3/2012/0052

From: David Hewitt
Sent: 01 June 2012 16:43
To: Graeme Thorpe
Subject: RE DILWORTH

Tre felling Plan Phase 1/2&3

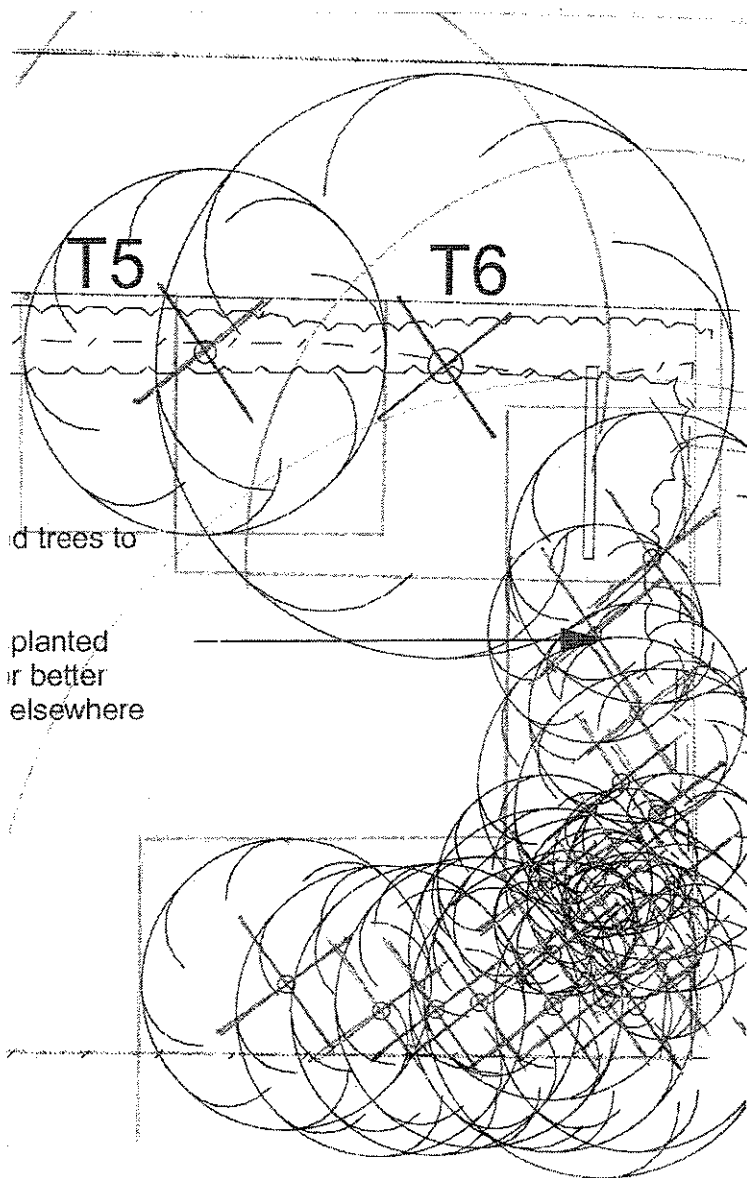
The tree T1 indicated for removal in order to facilitate the visibility splay, as required by LCC Highways, is a Horse chestnut recorded as suffering from Phytophthora fungal disease in the tree condition report submitted with the application. The report goes on to state that the tree should be felled, this conflicts with the tree constraints plan submitted with the application which states that the tree be monitored, therefore retained

The tree in question is recorded in the arboricultural impact/tree survey report as a category B tree [this category includes trees that may be of moderate quality and value, those trees in such condition as to make a significant contribution but that also may have impaired condition or defects and that should have a minimum of 20 years safe and useful life span]

The loss of the tree in question will have some impact on the tree covers visual amenity value but being at the end of a line of trees the impact may not be as significant as it might have been if the tree was in the middle of the row/avenue.
